A submission to Project Application 08_0194 – Kings Forest.

It is my submission that, for reasons set out below, this application is not fit for approval, and that unless amended, should be refused.

DRAWING TITLE  
**KEY PLAN  
 BULK EARTHWORKS**

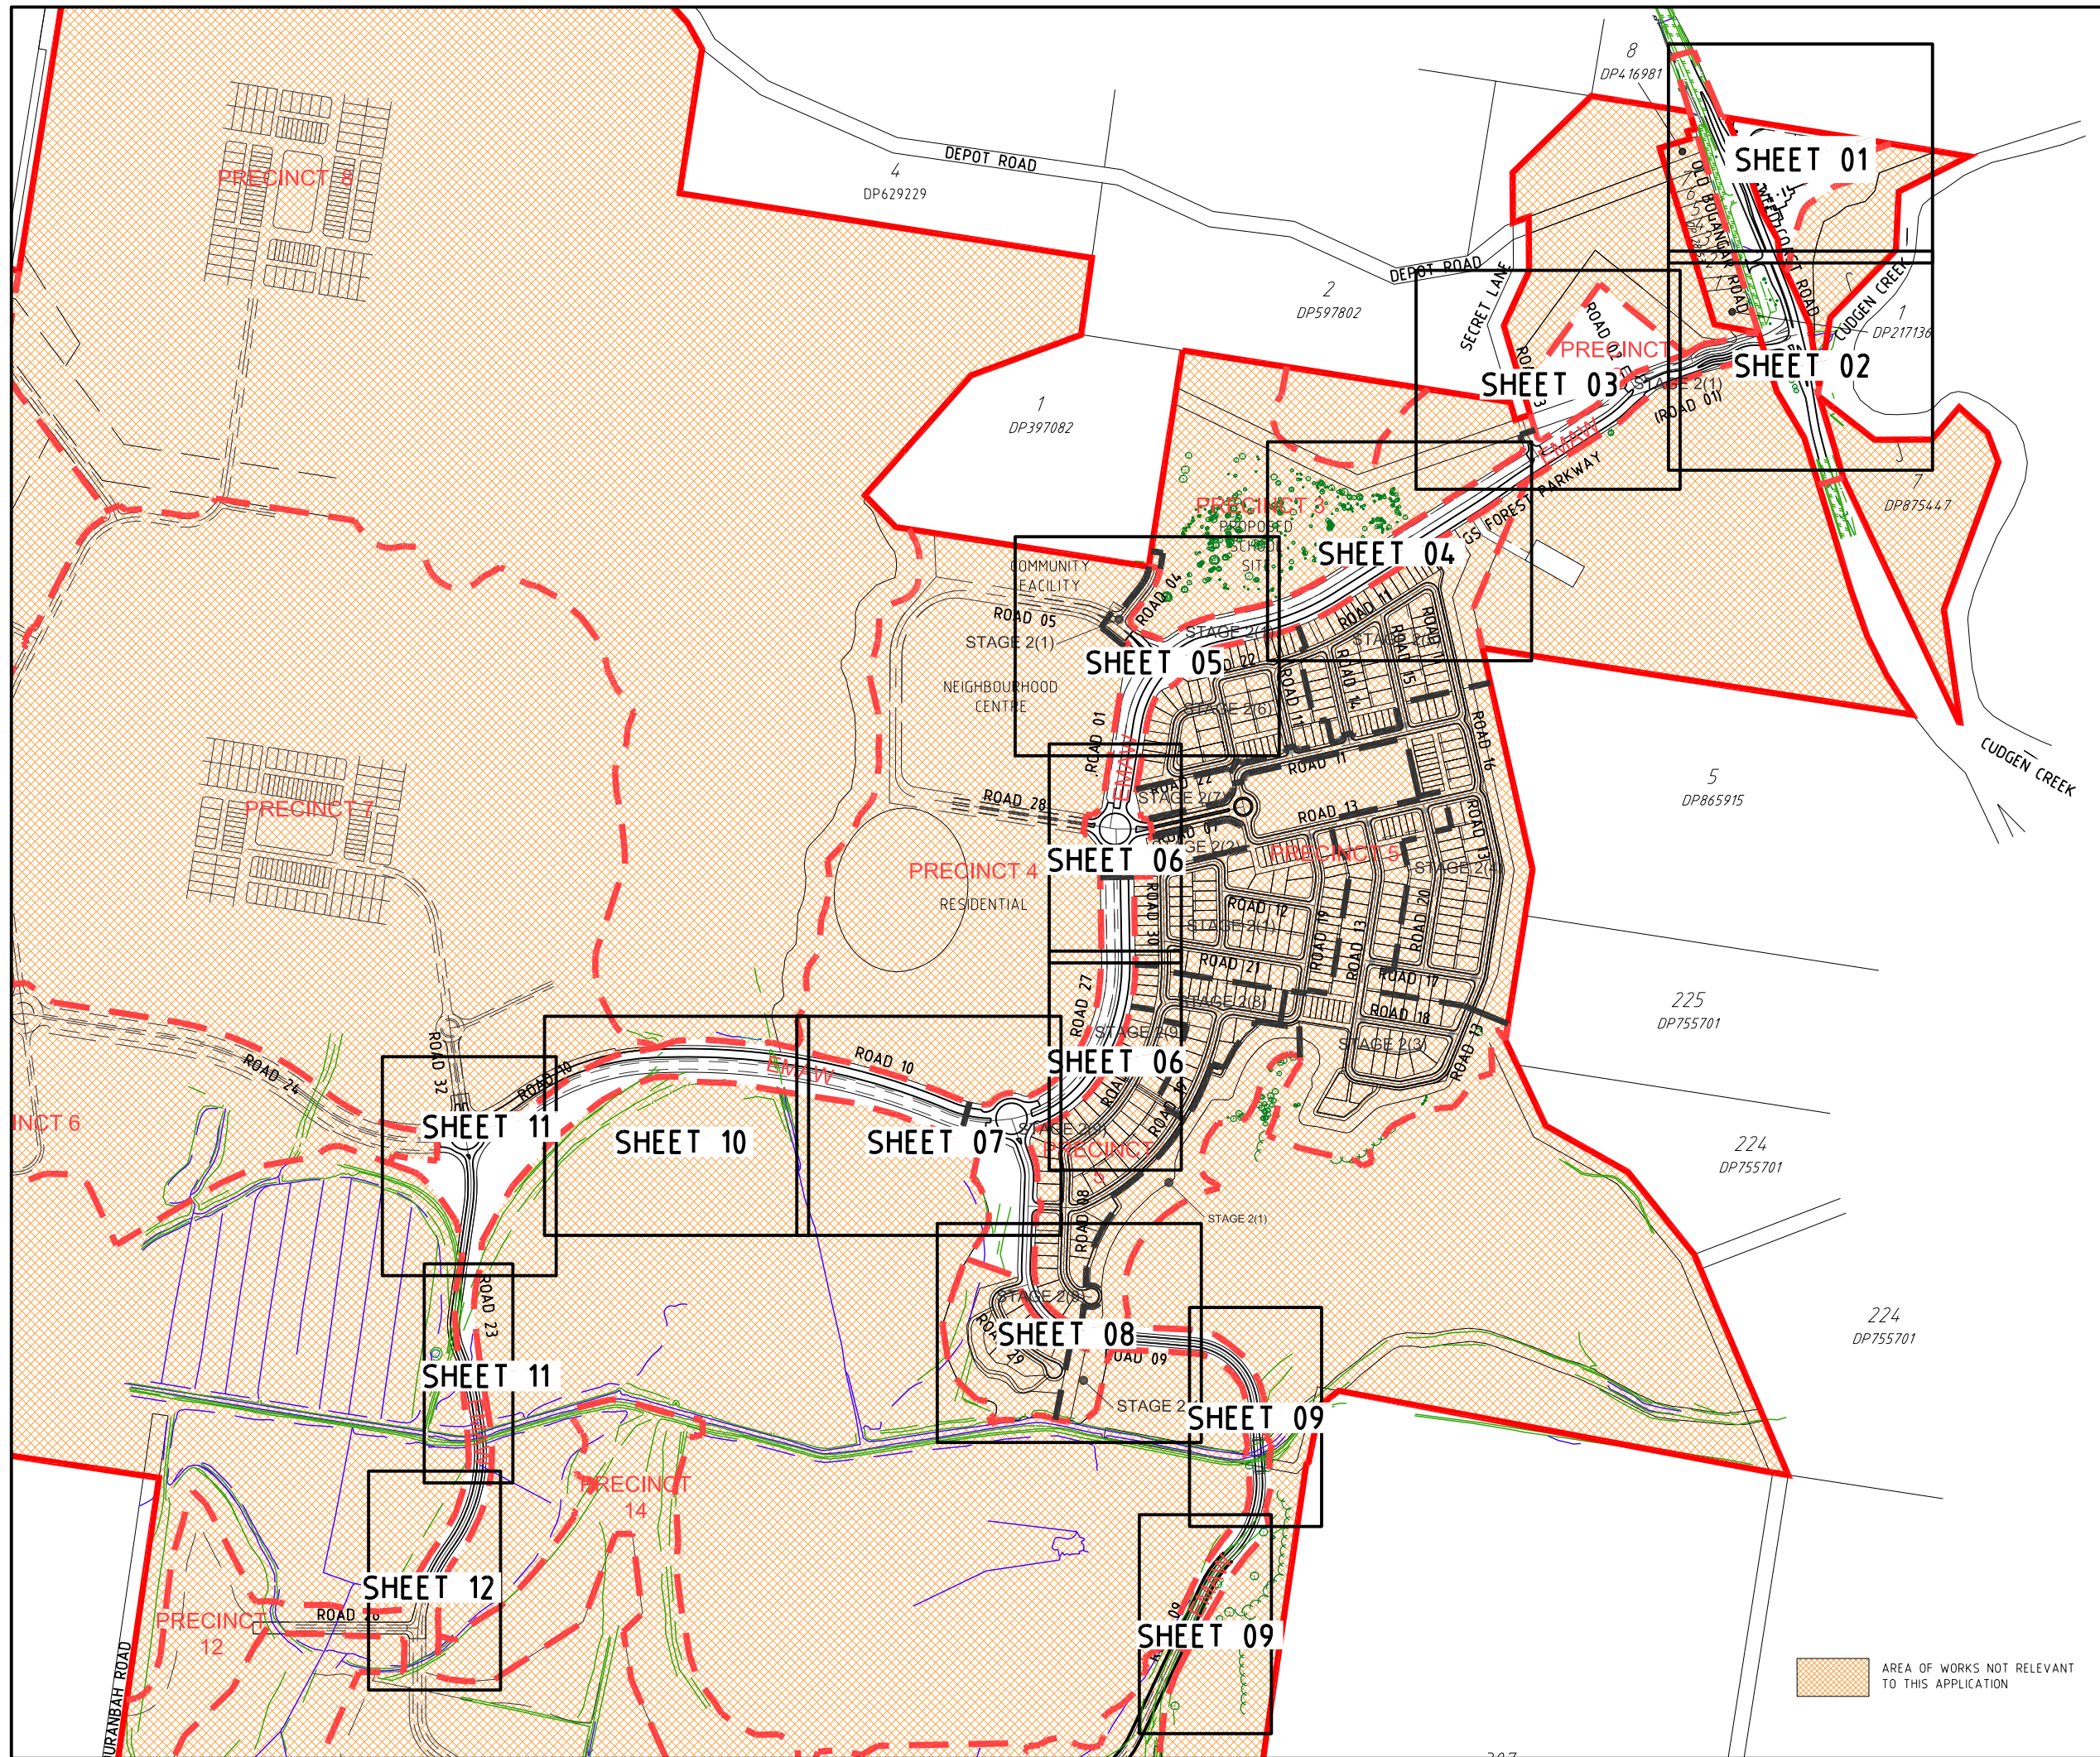
At Section 3.11 of the EAR, it is said that Stage 1 of the Project Application involves “bulk earthworks (in) precincts 1, 2 and 3...”. At Section 3.2 of the EAR there is an exposition of bulk earthworks for which approval is being sought and references to Figures in Appendices (the references numbers are wrong!!) and to Figure 2 in the EAR itself. None of the figures referred to depict earthworks in precinct 3.
